RFI

RFI #: 40
Date: 1/26/2012
Job: EB-02 Keller Springs Lofts
Phone: 877-777-5115

Subject: 8 x 8 Wood Posts

SHEET NUMBER
3.1C
BLDG PLAN 'C'

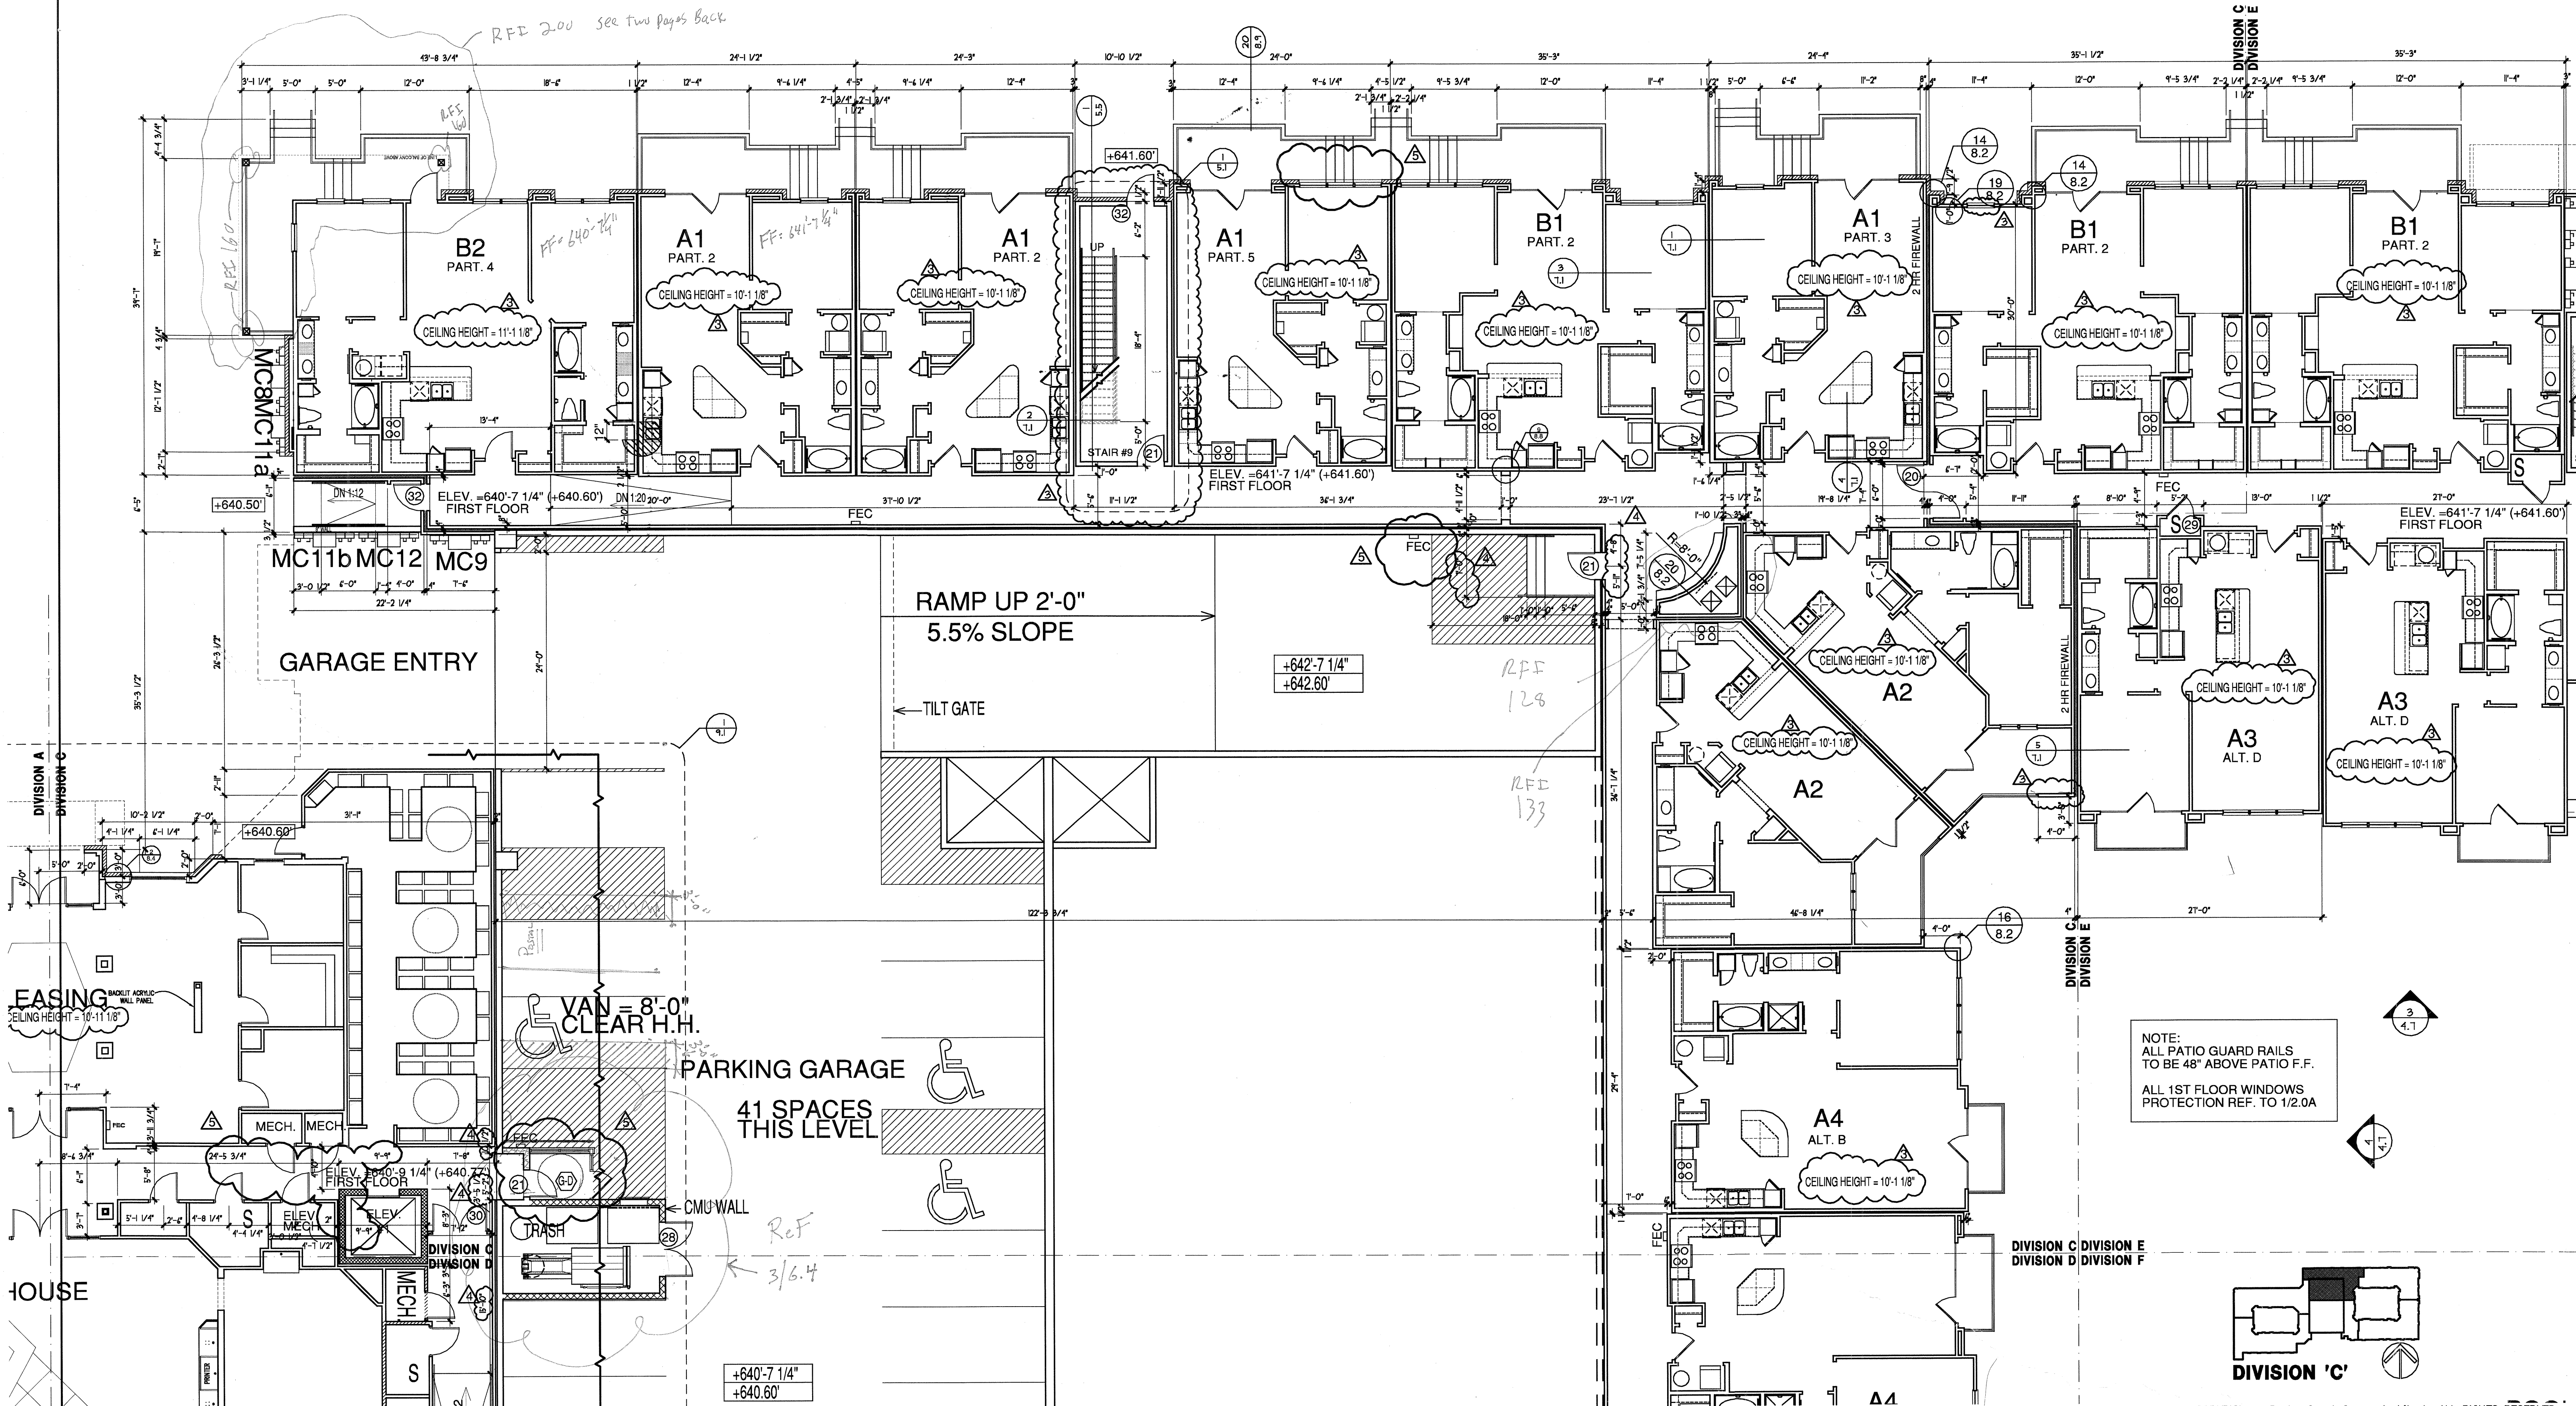
Request:
Unit #1143 is a B2 Partial 4 unit. It is the only unit of this type on the project. It has three exterior columns that structurally support the building above. 2.7A shows the location of the 8x8 post per RFI #160 as does 3.1C. Landscape sheet 2C also shows the slab foundation elevation at 640.60' and the patio elevation where (2) of the posts are located at 638.60' structural detail 11/S3.01 shows a 2x2' area around the post but if that is the top of the patio slab the thickened area would protrude past the edge of the patio. S2.13P calls for 16" piers under each post at finished elevation of 634' 3 3/4" which is 4'-4" below the (2) posts on the west side of patio and 6'-4" below the (1) post up on the porch coming out of the unit. Also, the pier on the porch at the higher elevation is not located where it's supposed to be on S2.13P. Please provide the structural information showing the proper height and location for the three piers. If a cap of some type needs to go on top of said piers at finish elevation, and what type of reinforcement needs to be provided at that cap along with details for patio and porch slabs, stoop, etc., see Architectural detail 2058.9 we are forming the 4th floor in the area and will be setting roof trusses next week. We need these columns to build the balconies above and set roof trusses. Please see attachments along with this RFI.

Response:
Please refer to attached sheets.
R. Trent Perkins, P.E.
Parkin-Perkins-Olsen Consulting Engineering, Inc.
August 24, 2012
